Please see an extract of a representation I have received . Can you provide comment on the differences between the plans and why it seems there is a difference in the approved drawings when they are imposed over the proposed by him?

CM/64/19/PL and CM/16/20/PL

Drawing Title:
HOUSE TYPE-F1
FLOOR PLANS

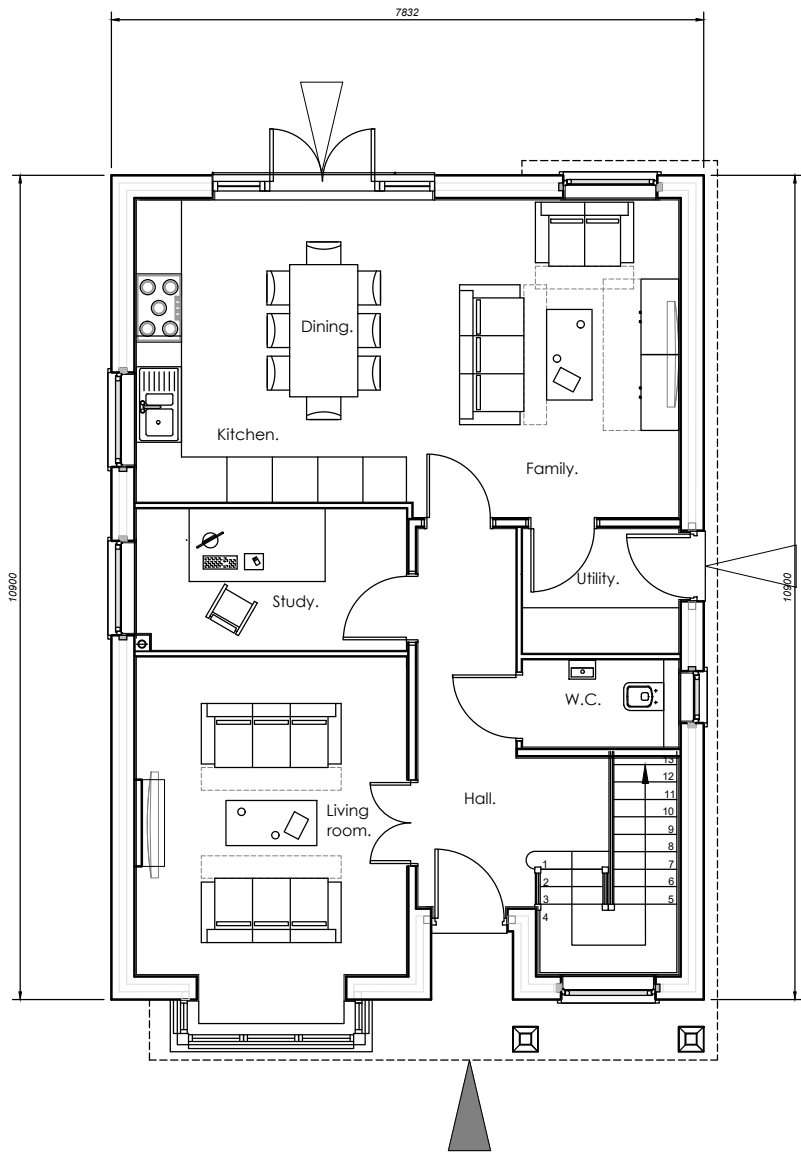
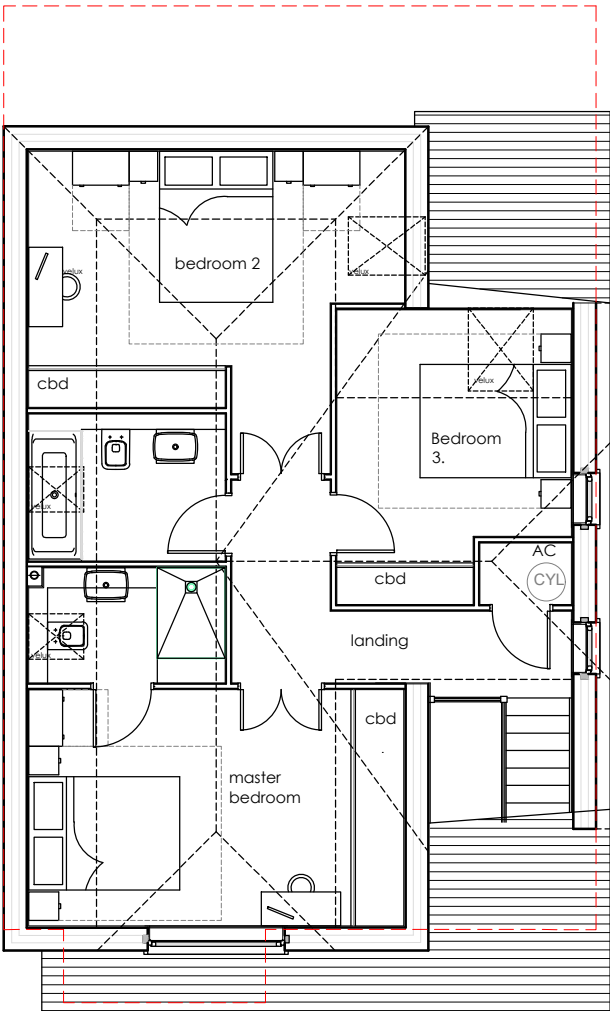
Below is a photo of the plans of plot 8, CM/64/19/PL and plot 8, CM/16/20/PL. I have traced the outline of CM/64/19/PL on to CM/16/20/PL. Both plans were drawn to the same scale as the widths of the two designs are identical and both were printed out on the same printer. You will notice that my red dotted outline appears significantly different to the one supplied by the applicant – see below. Not only does the roof appear higher but also longer. This leads me to believe that either the original plans have been altered or the architect has made a mistake drawing in the red dotted outline on the new plans.

The length of the house is as shown, however the positioning of the plot is relative to the parking bay in front, consequently we have tried to move new the plot as far north as we can so as to limit the impact at the rear. To locate the plots, the corner of the window bay is the same in both versions (as per the plans I sent you recently) but the posts and overhangs are not the same in both schemes, hence the slight difference in appearance/length.

I would also add the latest drawings are based on a construction/technical drawing to ensure the actual internal dimensions/clearances required are being achieved. I hope that helps.
